From: Laura Gibbons <Laura.Gibbons@arun.gov.uk>
Sent: 27 October 2020 15:59
To: Planning.Responses <Planning.Responses@arun.gov.uk>
Cc: Michael Eastham <Michael.Eastham@arun.gov.uk>
Subject: BN/97/20/PL- angels nursery

Drainage Engineers Comments on Surface Water Drainage

7436 7436-SA-002 -

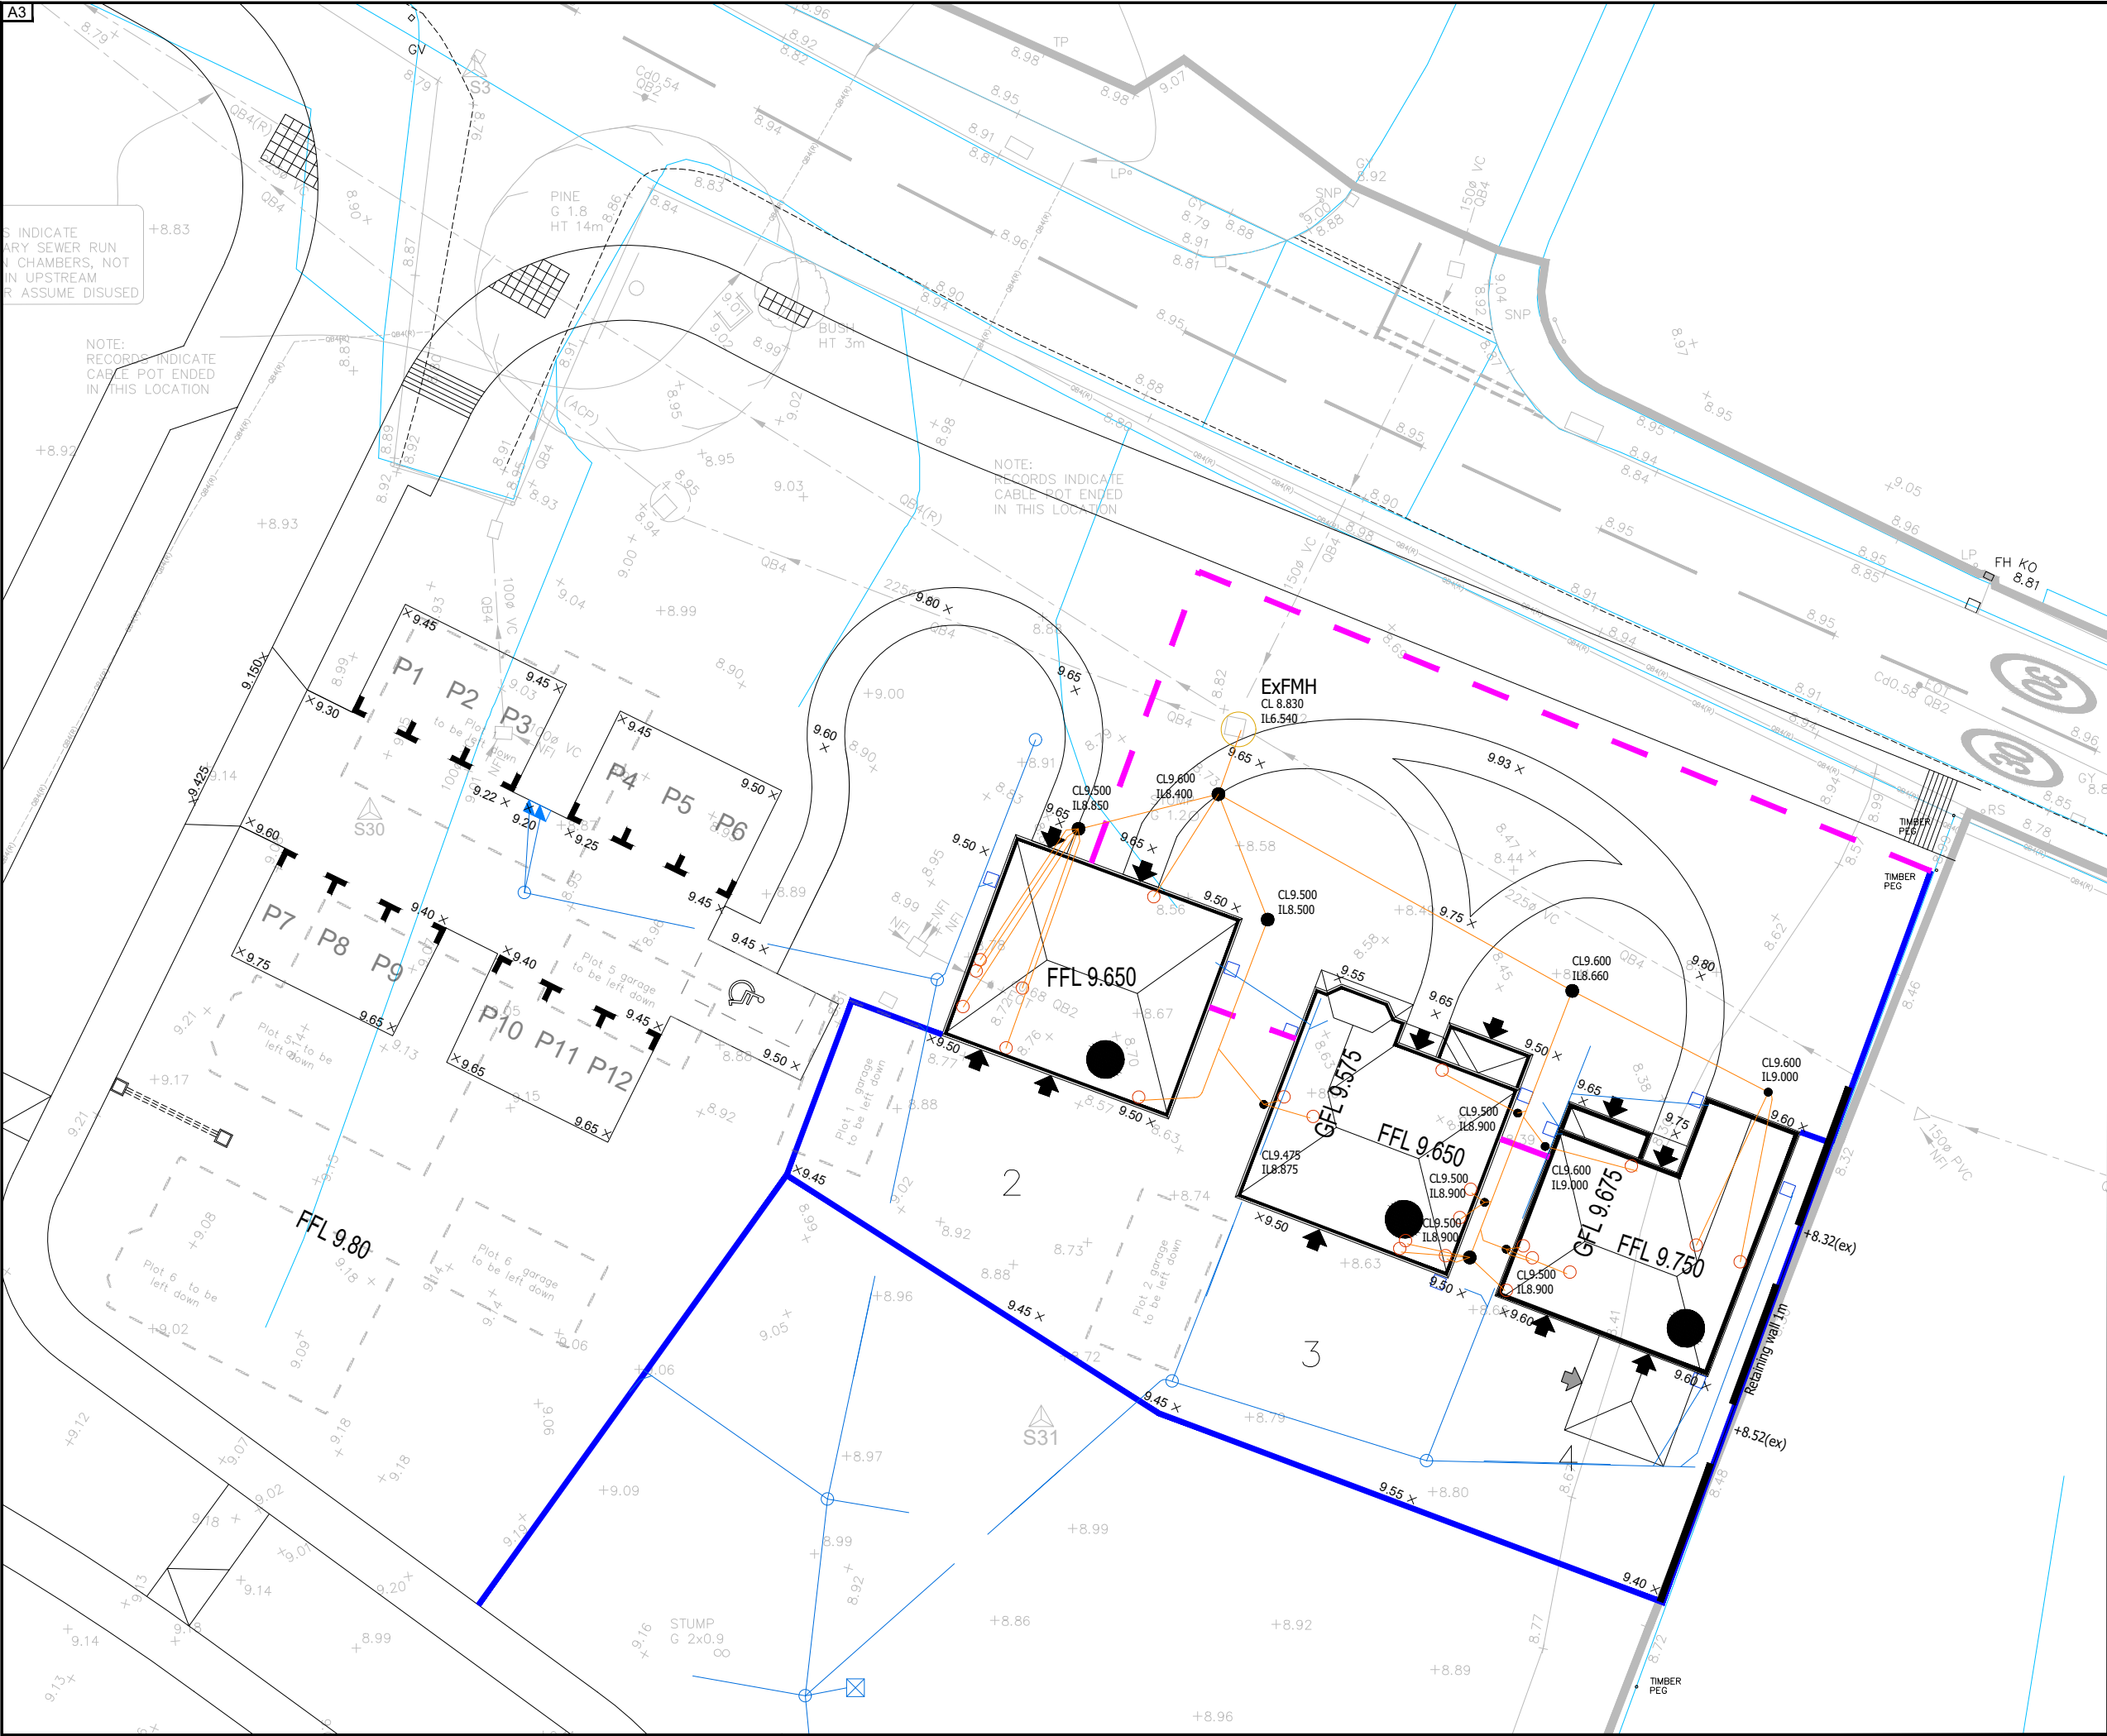
The drainage statement submitted does not support the layout plan. Please can the applicant identify if the proposals amount to a change in impermeable area over the previously approved drainage scheme. Please can they also supply details of how this revised layout will be drained. Until such a time as this information is submitted we wish to raise a holding objection.
